Rio Grande Credit Union

Administrative Amendment Request

Project #PR- 2020-003561

Transportation Development Comments:

NOTE: ASPHALT ABUTTING THE EXISTING PARKING LOT TO BE AT SAME ELEVATION. SLOPE ALL NEW PAVING AT 2% SLOPE TO THE WEST. INSPECTOR TO VERIFY

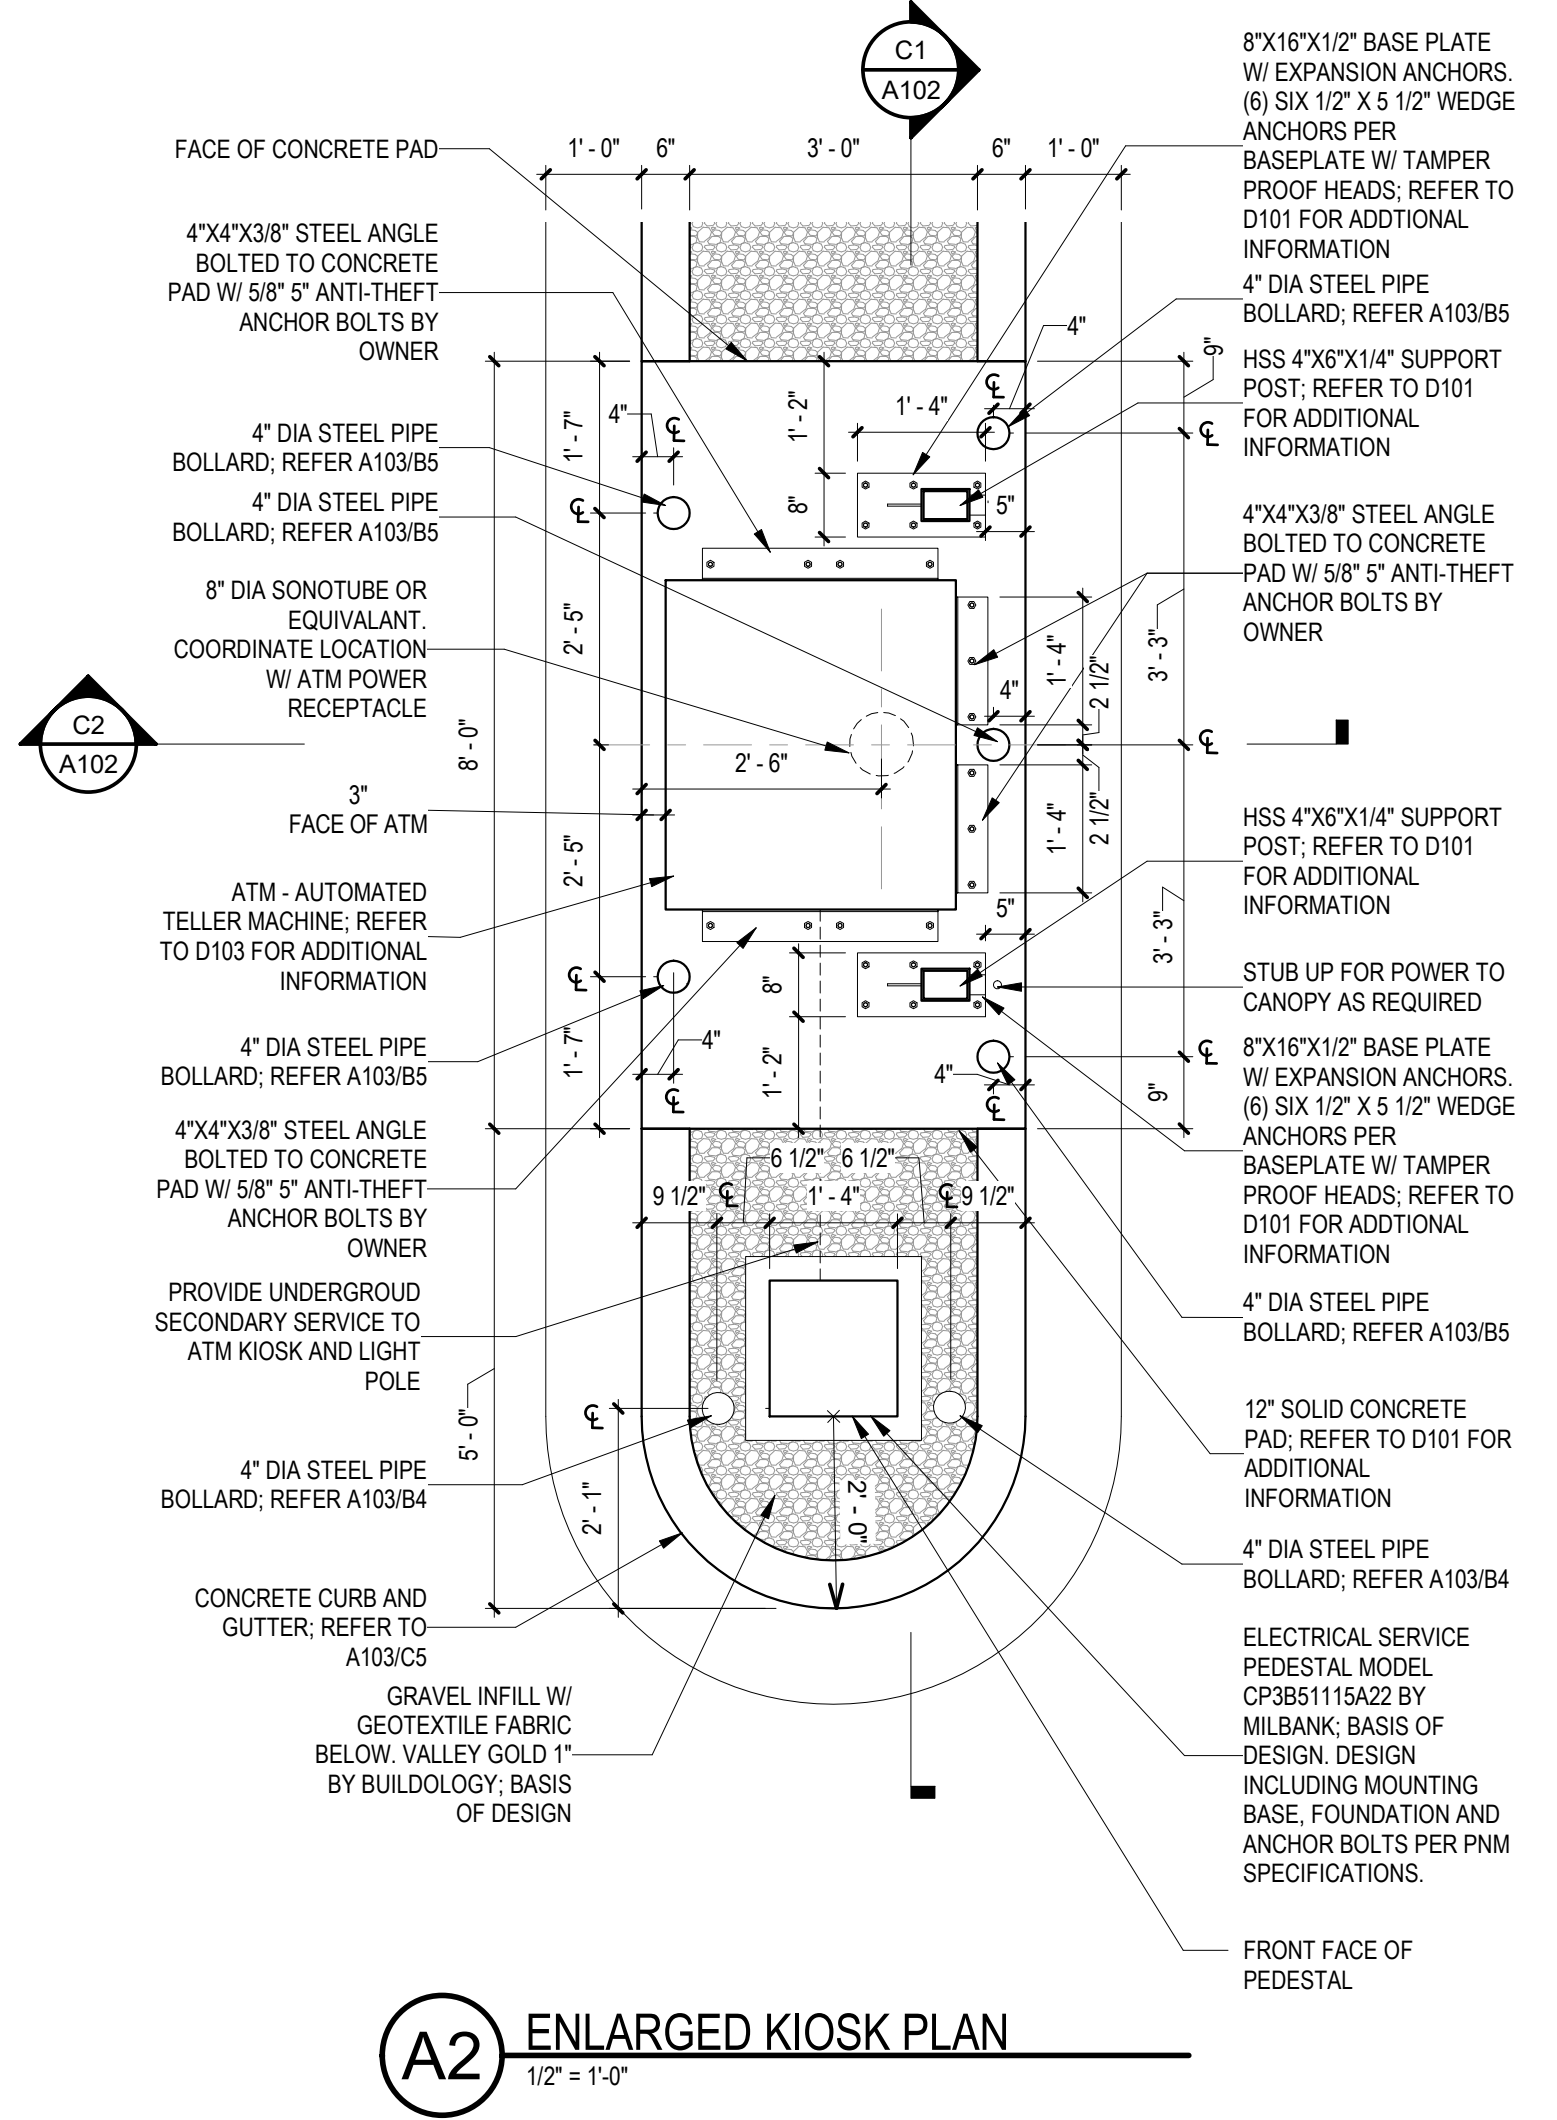
- On Sheet A102, based on dimensions provided, the bollards and adjacent equipment appear to be in conflict with the proposed curb and gutter. Modify dimensioning as needed to eliminate the conflict.

A3 TRAFFIC SIGNAGE
1/2" = 1'-0"

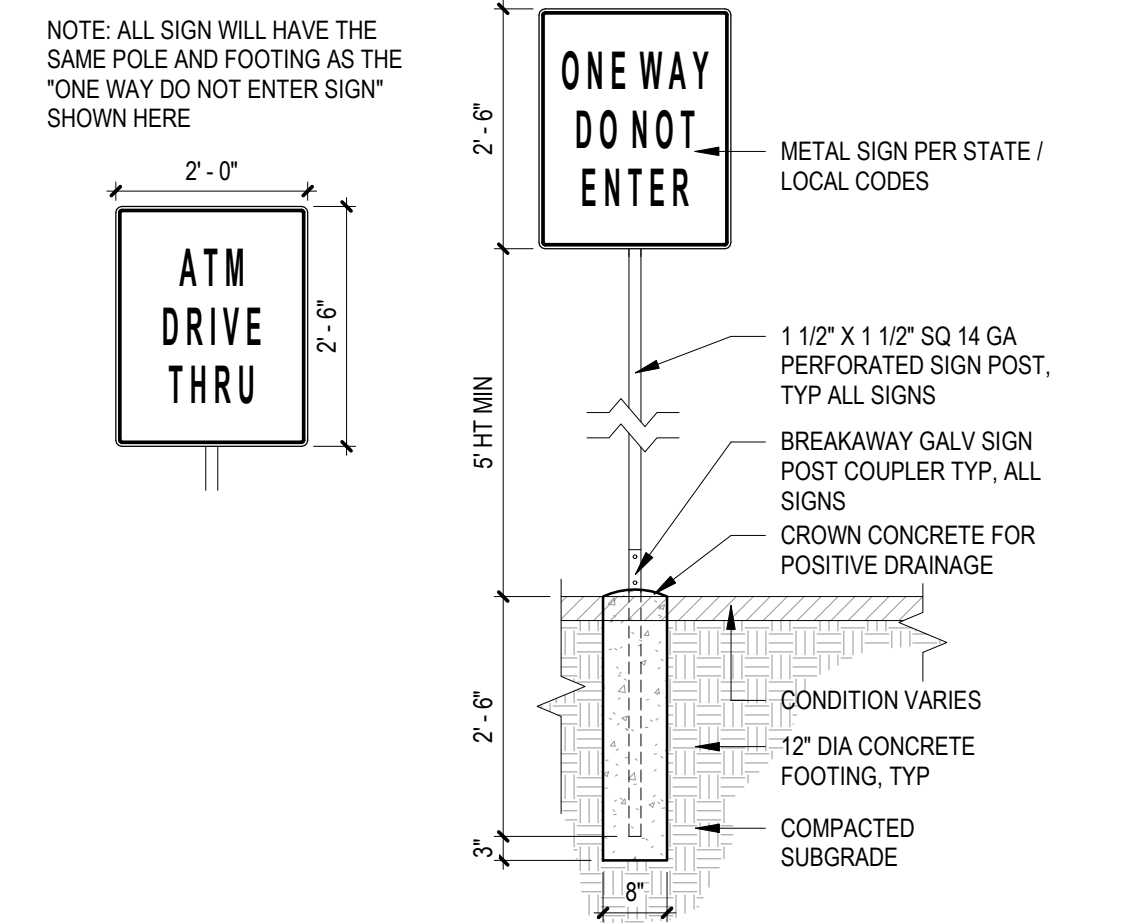
- Provide a pavement directional arrow at the exit point for the bank drive-thru in addition to the "Do Not Enter" sign.
- The detail for the "Do Not Enter" sign on Sheet 2 of 5 does not meet standard. Delete reference to this sign detail, and use the "Do Not Enter" sign per MUTCD sign R5-1. Likewise, on Sheet A103, reference R5-1; "One Way" sign is R6-1 and would be a separate sign oriented parallel to curb for the exit although a "Do Not Enter" sign is sufficient in this case.
